Recommendation Report for Planning Permission for Works or Extension to a Dwelling

REF NO: AW/380/21/HH

LOCATION: 130 Nyetimber Lane
Aldwick
PO21 3HR

PROPOSAL: Removal of existing side projections and erection of two storey and single storey extension.

sheet 1 of 4

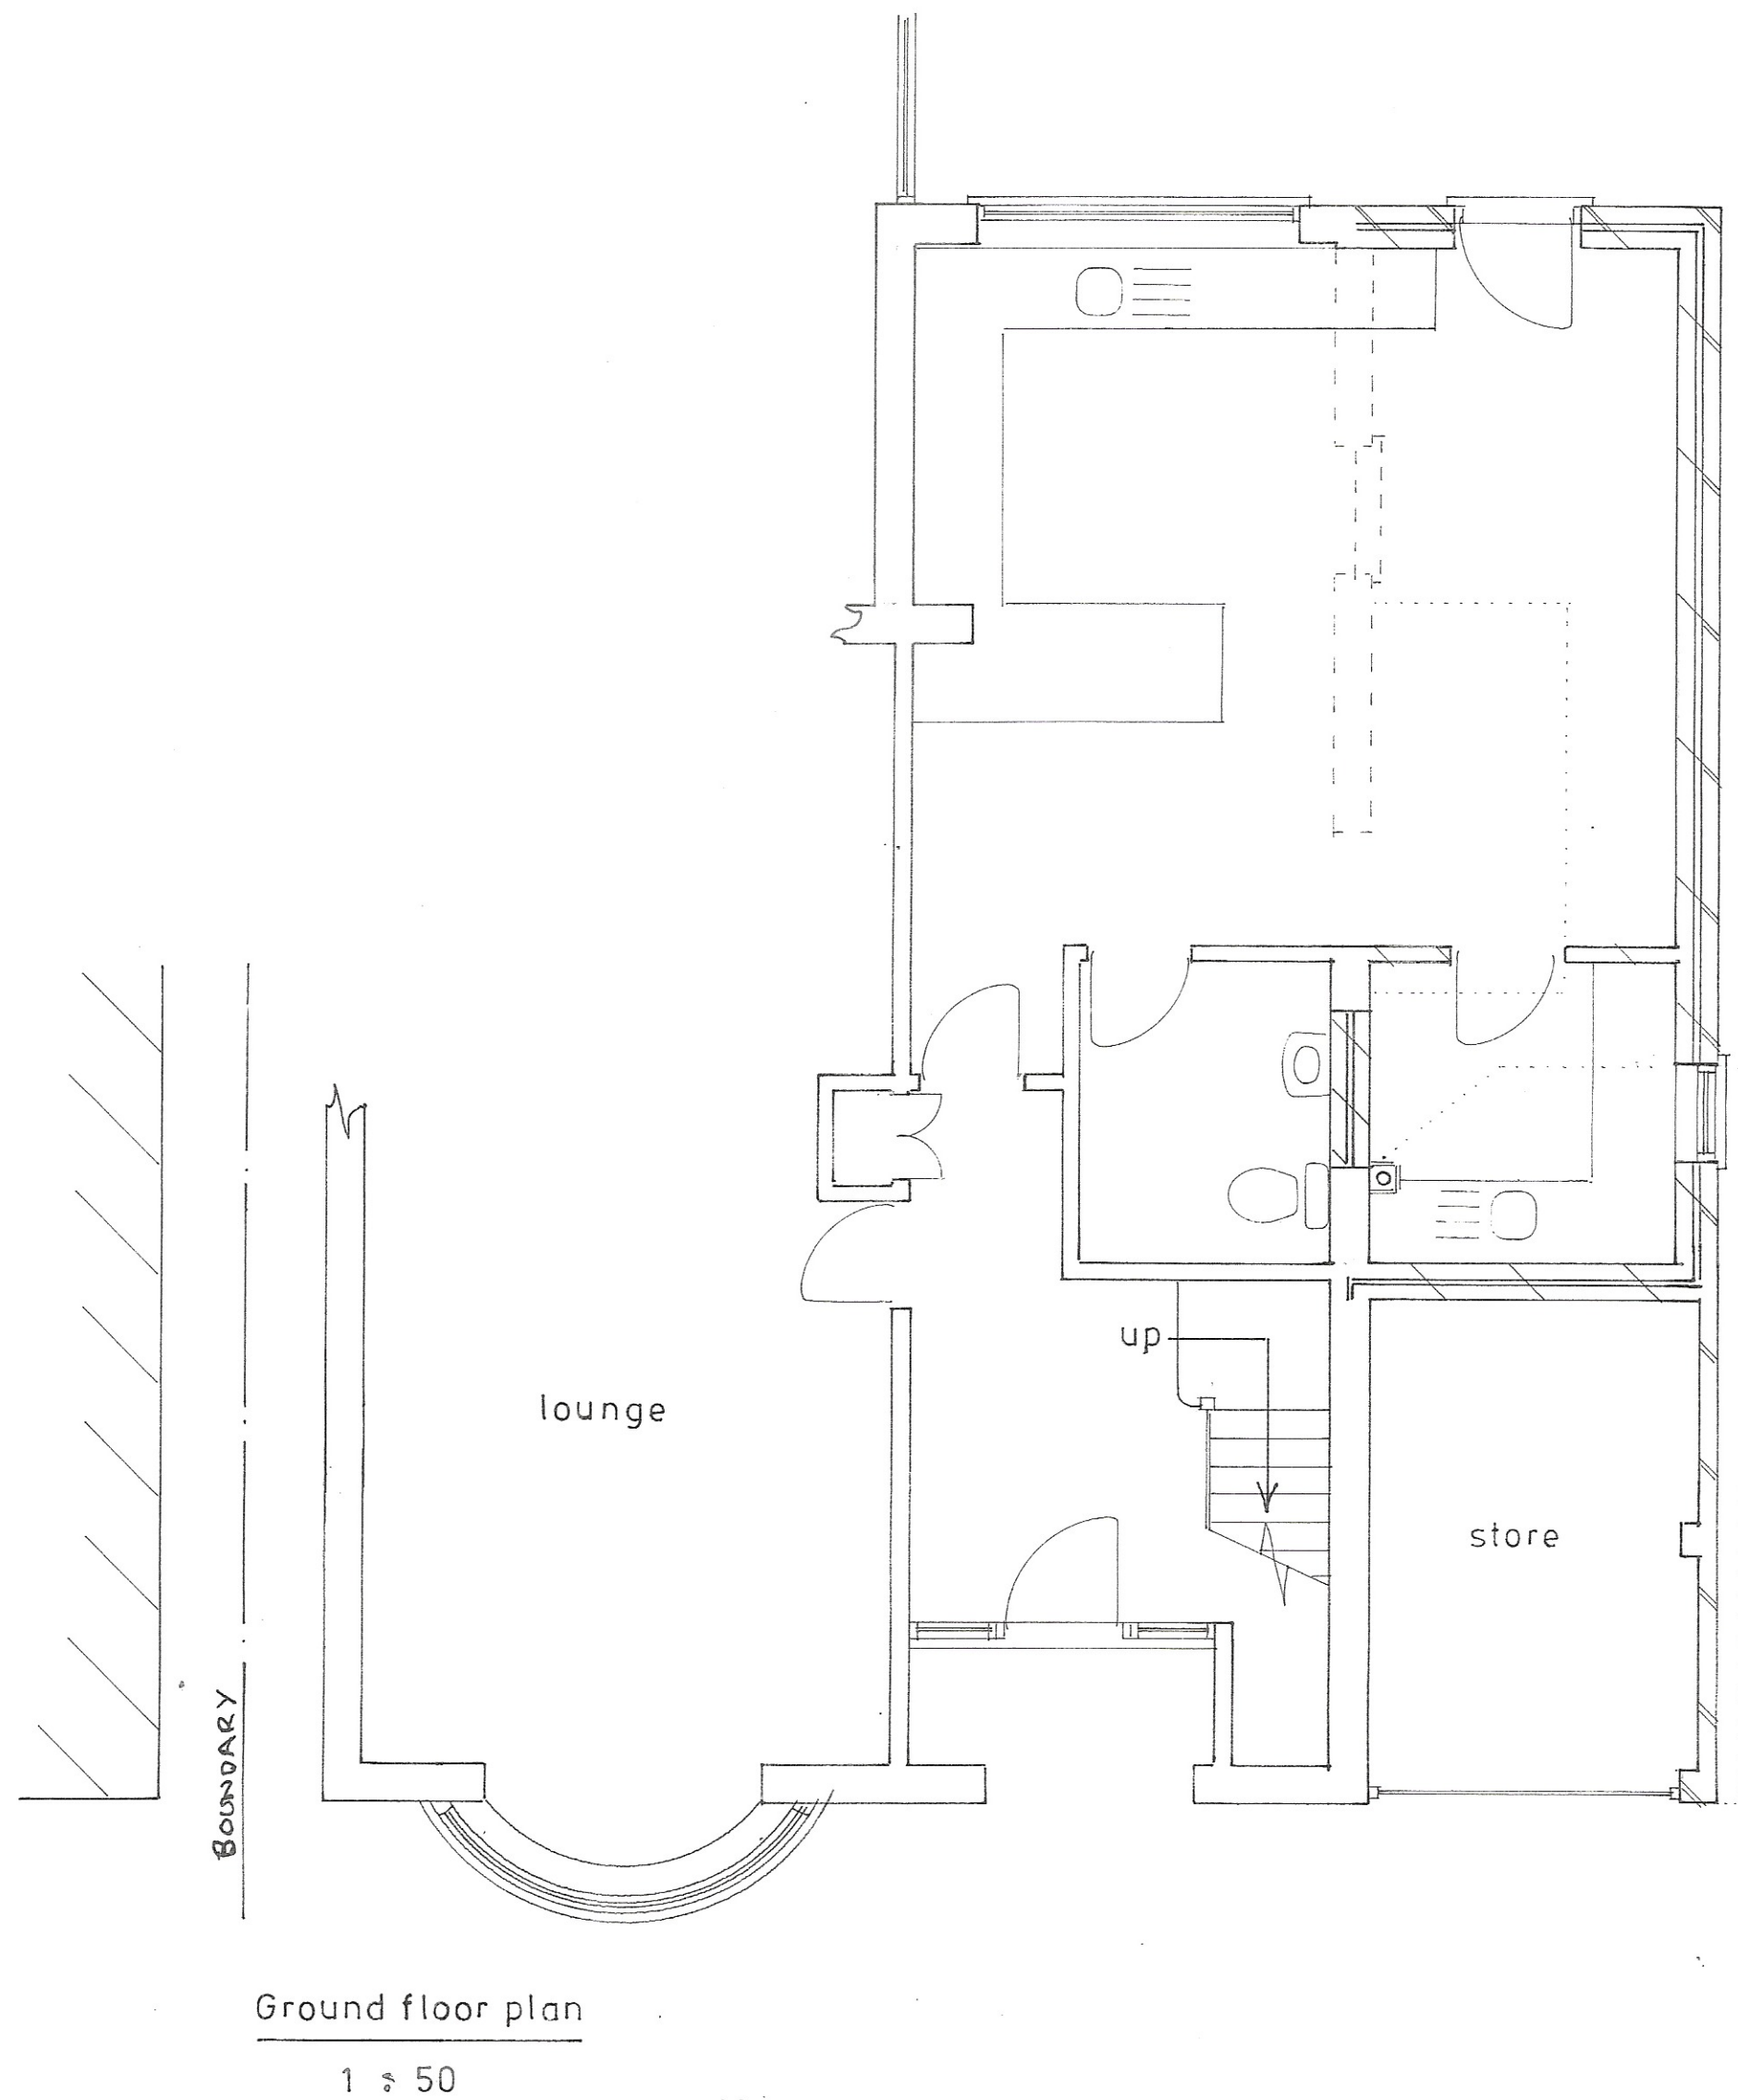
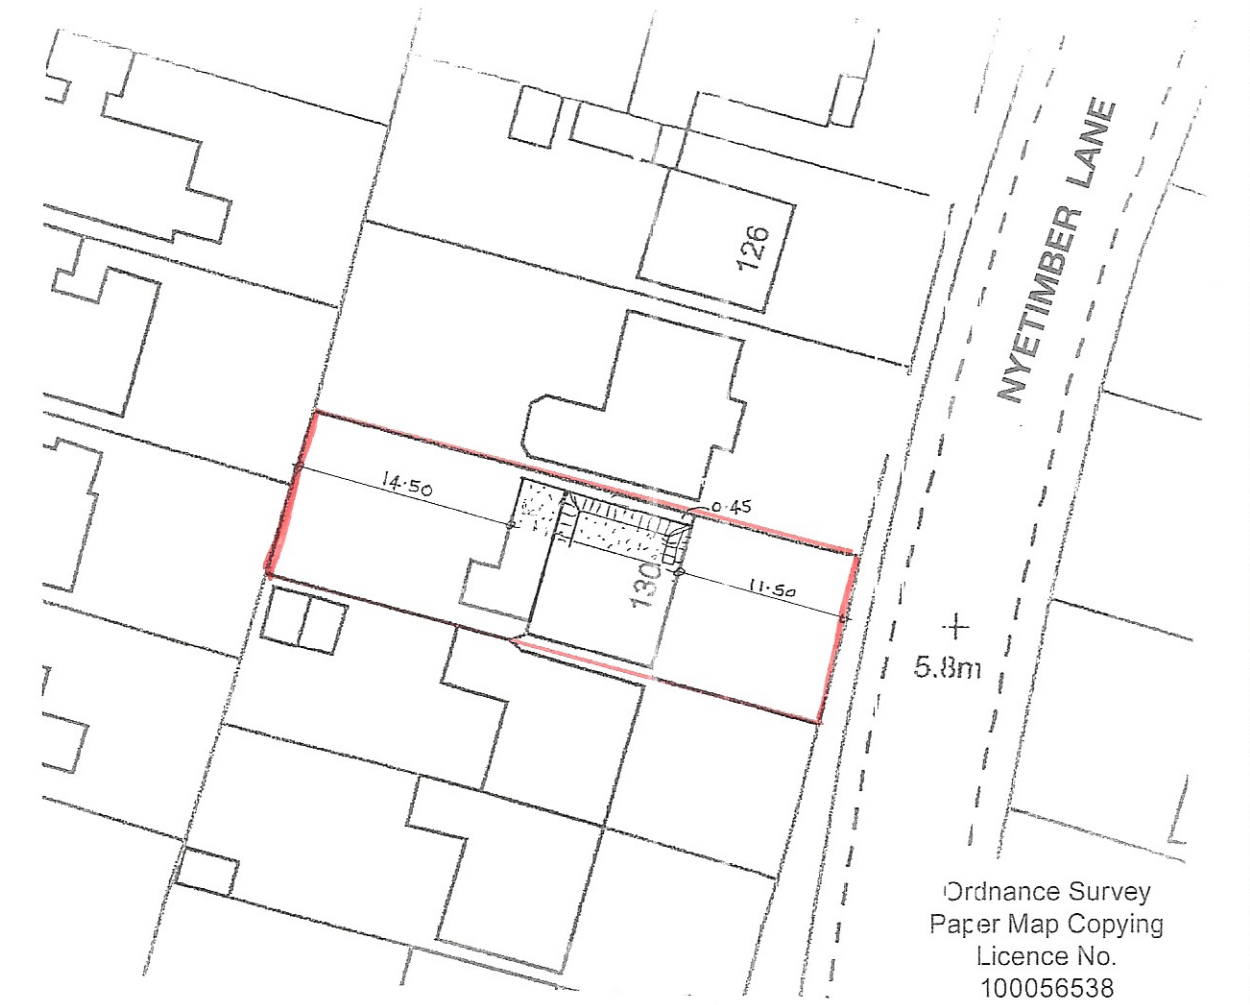
The single storey element will infill the rear of the garage meeting with an existing conservatory. This is modest in size and not visible from the wider area.

To the ground floor there is an existing extension located from the centre of the rear elevation extending south. There is an addition attaching this, serving a toilet which will be removed. The proposal essentially infills this space with the extension meeting with the side elevation of the dwelling and rear of the garage.

The extension will have a flat roof height of 2.7m and extend in line with a conservatory located to the neighbouring side. The extension may give rise to some minor overshadowing although with a modest height and boundary treatment in place, and with the conservatory featuring glazing to all elevations, this

There will be a door to the rear of the ground floor extension with no windows to the side elevation.

sheet 2 of 4

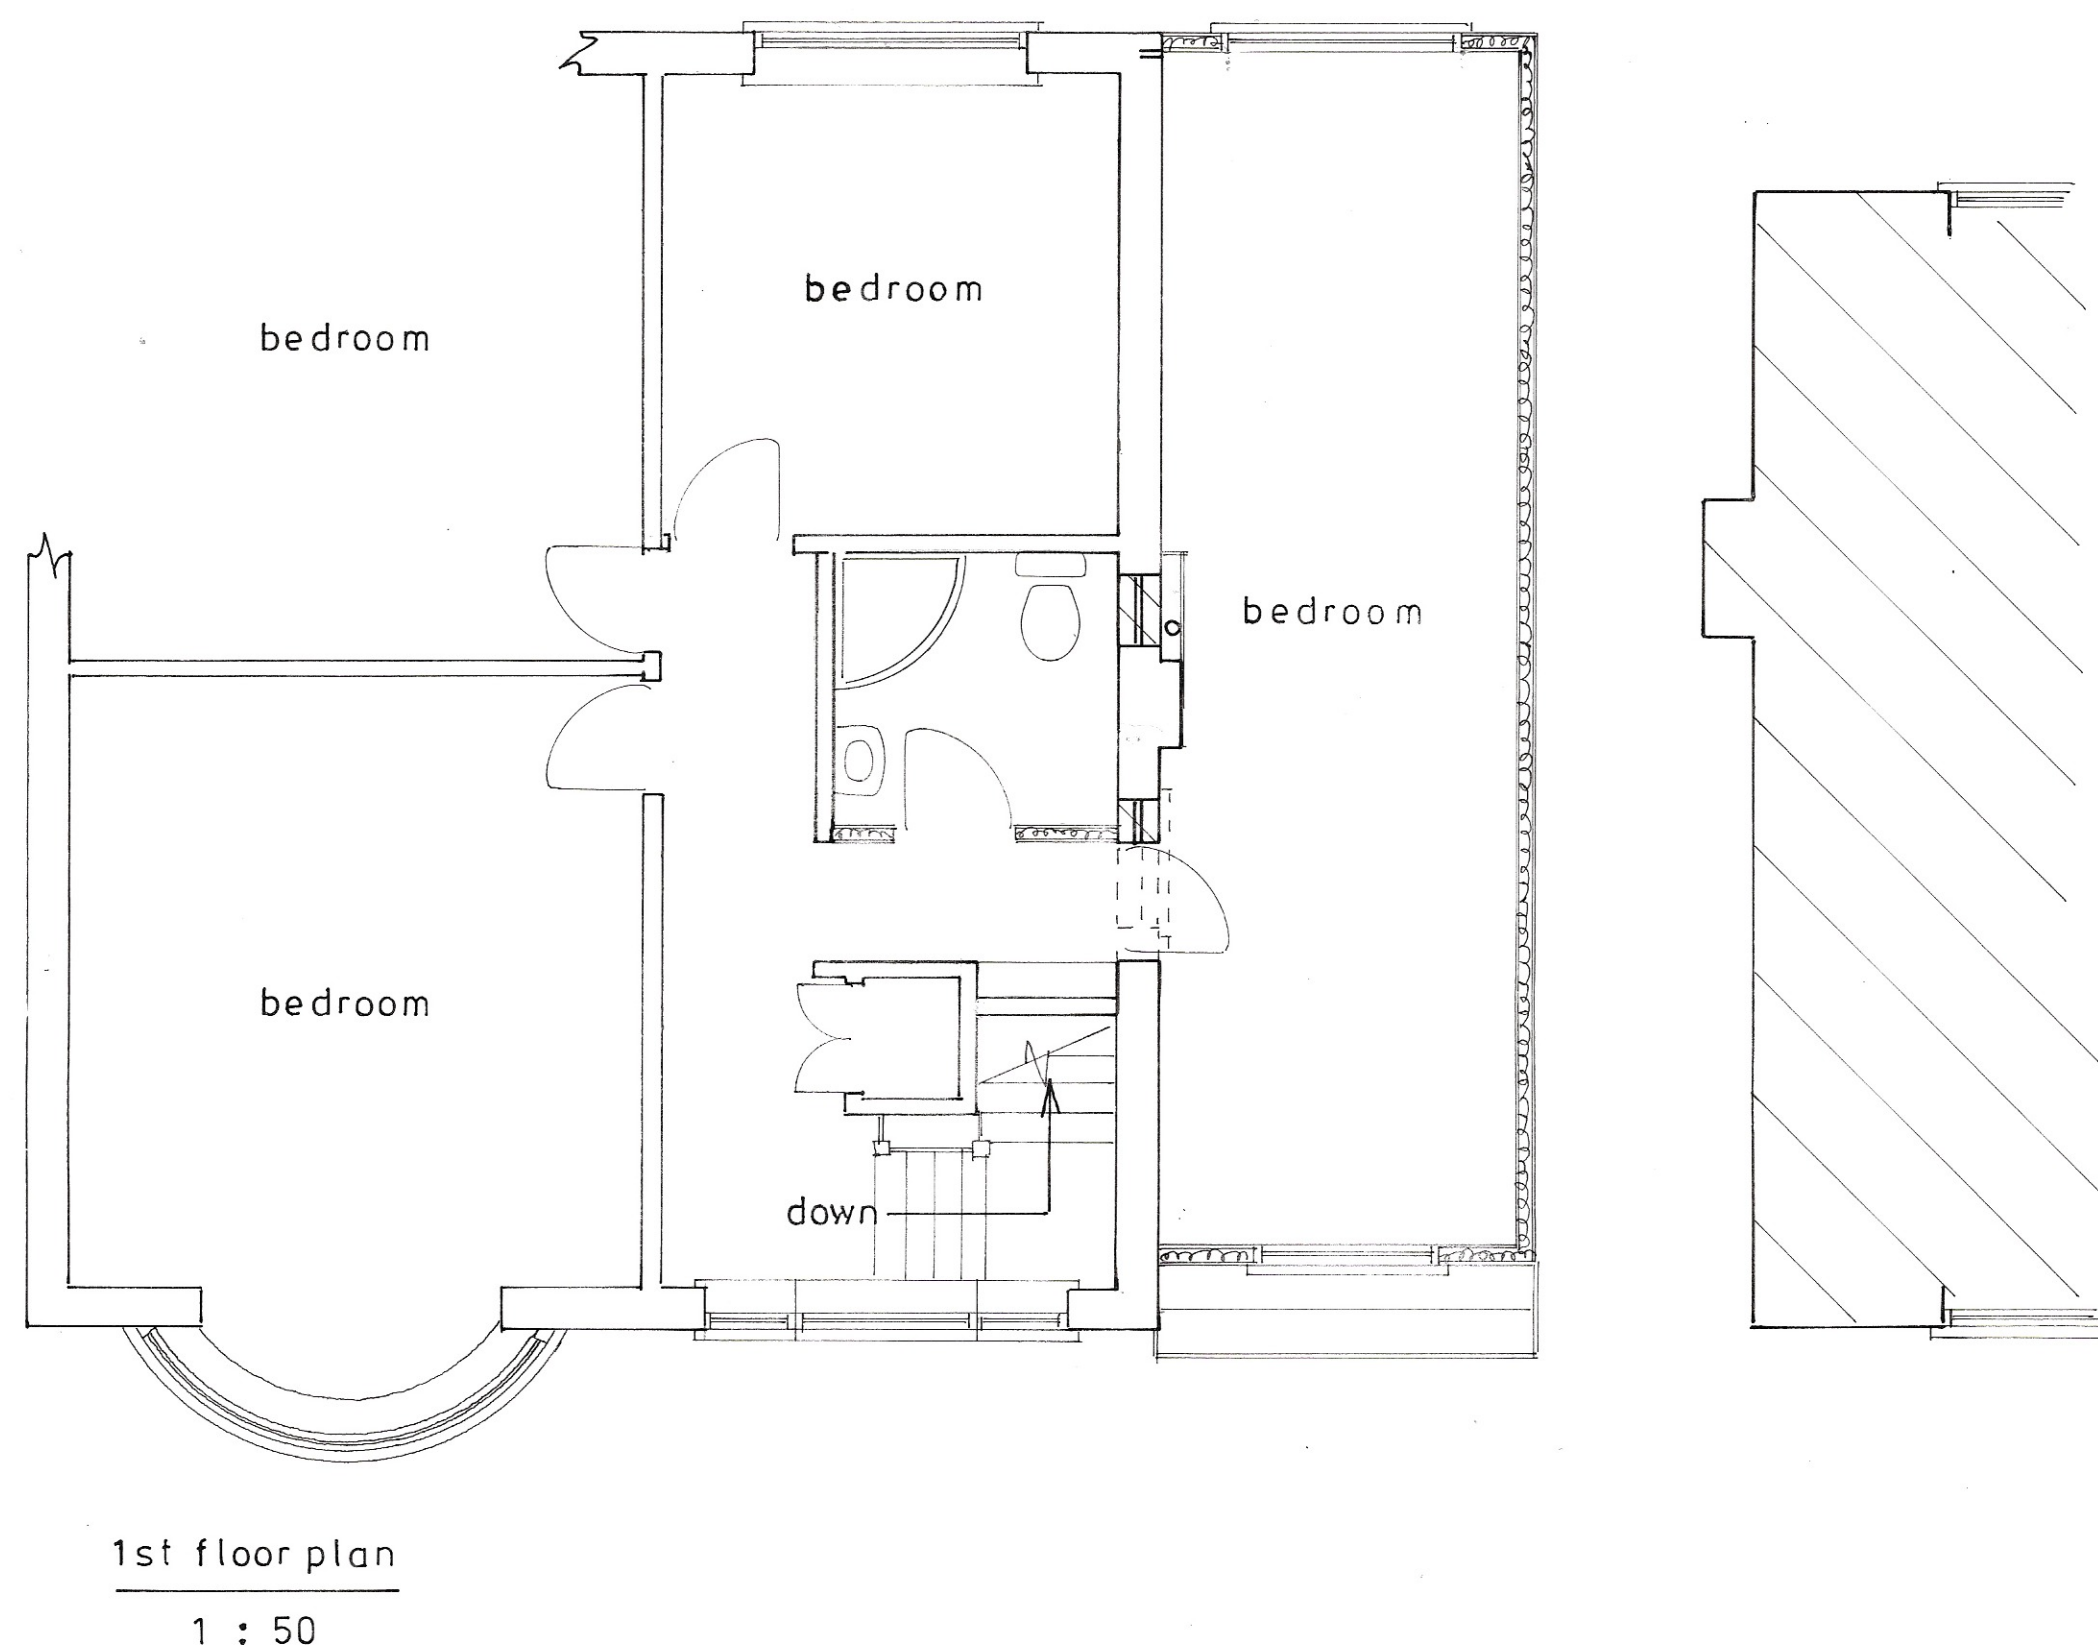
The host dwelling is detached two storey property with an attached garage and a first floor is proposed above the garage. being located to the side of the property, is highly visible from the street scene.

Due to the siting of the first floor, this would conflict with D DM4 (d) in that the first floor would result in relatively small gaps at first floor level between buildings, in that it comes within 1m at first floor level to the side boundary. However, it is not considered this is would result in a significant impact in which a refusal is justified. This is due to the mixed character of the properties within the street scene which feature a variety of gaps between properties and not result in a terracing effect.

The first floor addition will have a hipped roof which sits below that of the ridge height of the dwelling and as such appears a subservient addition. Materials proposed will consist of matching roof tiles and white cladding to the first floor addition. Whilst cladding is not present within the street scene, its use is not considered to appear out of character and being white in colour will be sympathetic to that of the host dwelling.

The Arun Design Guide states ' Extensions should in most cases be set down from the existing roof ridge height by a minimum of 0.5 metres, and should have a building frontage no greater than 70% of the existing building . The proposal complies with this. 'In streets characterised by small gaps between buildings, extensions must not close important gaps in the street scene by leading to a terracing effect. This can generally be ensured by keeping extensions at least 1 metre away from the side boundary.' It does conflict with this element of the guide.

Whilst the proposal will result in the extension being located within 1m of the neighbouring side, it is not considered this results in the a significant terracing effect in which the dwelling appears out of character with the area. As such it complies with D DM1 and D DM4 (a)(b) and (e) of the Arun Local Plan.

Due to the siting of the first floor addition to the side of the property it does not appear overbearing or overshadowing upon neighbouring amenity to the northern side. The addition does not extend beyond the building line or intersect a 45 degree angle when draw from the closest window at first floor level. There are also no windows to the side elevation of No.128 which would be affected.

There will be an additional window to the front and rear at first floor. This will provide additional views over the rear gardens although views are not considered to increase significantly from that which can already be achieved.
